APPROVED
Contract Building with Insulation
Permit holder responsible for full compliance with the code.

08/04/2023

125 Irene ct
Fuquay, NC

SHEET:
A-1

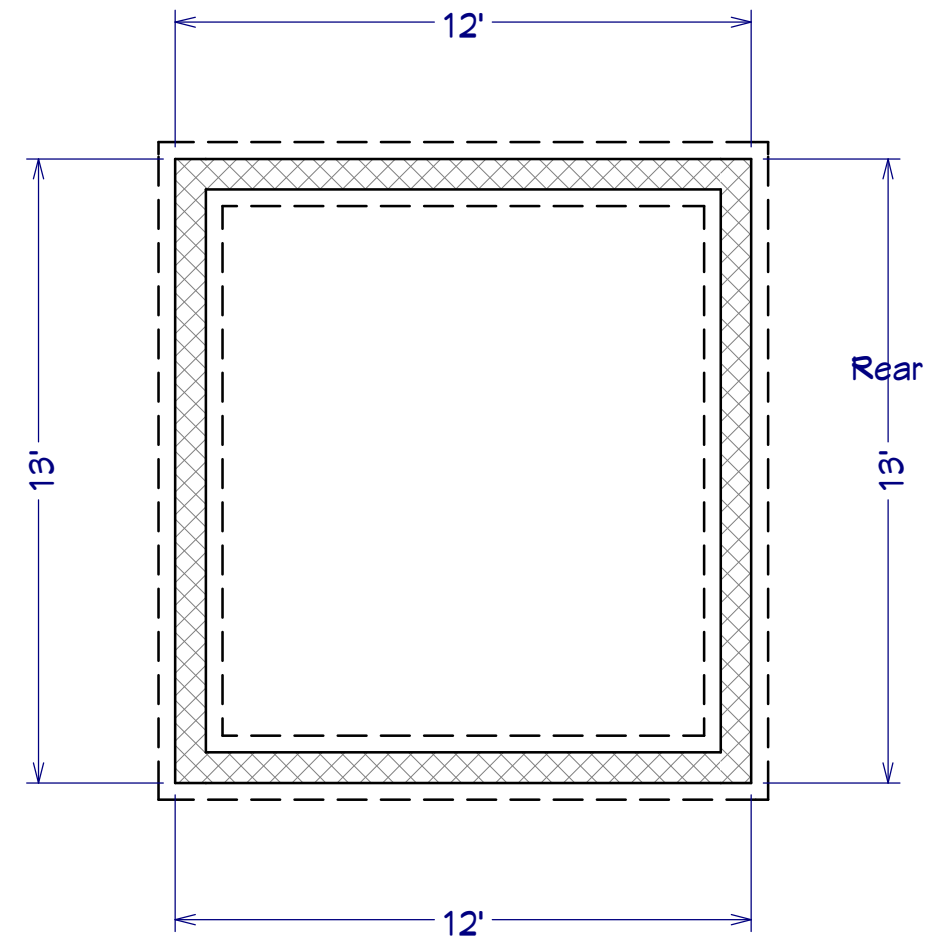
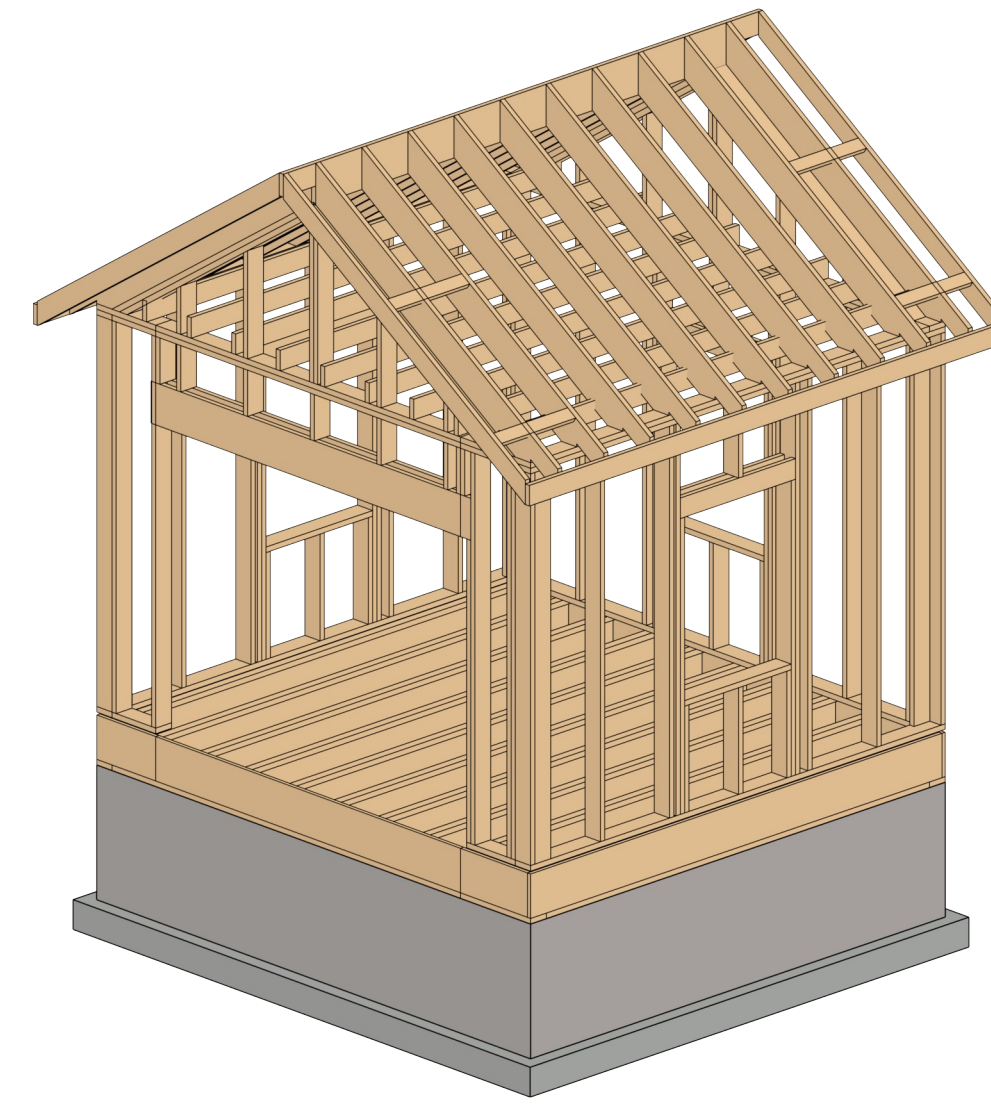
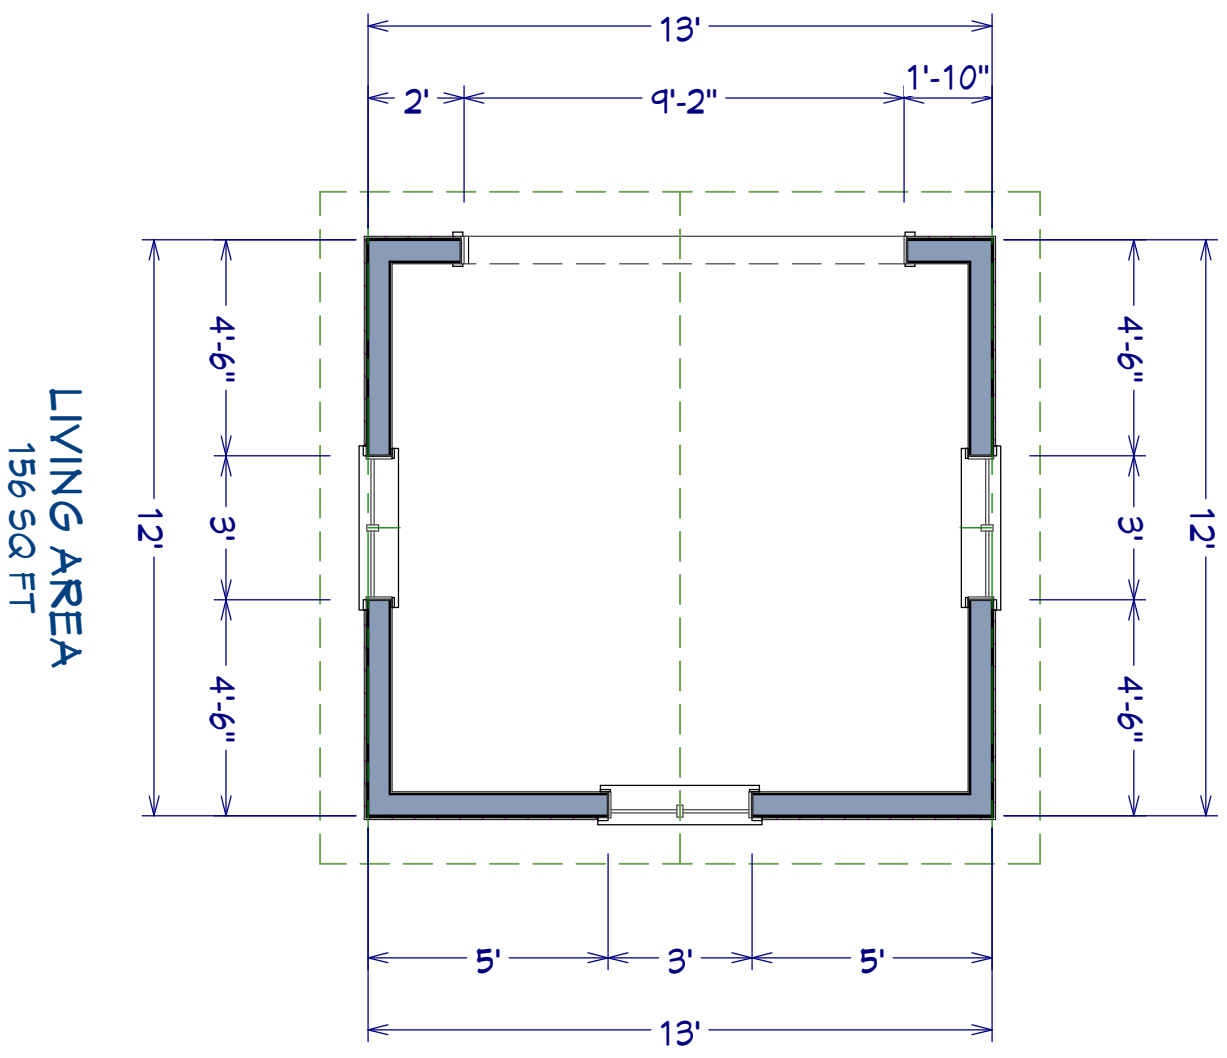
R-38 minimum

Windows must meet energy code

sheath with 7/16 osb minimum
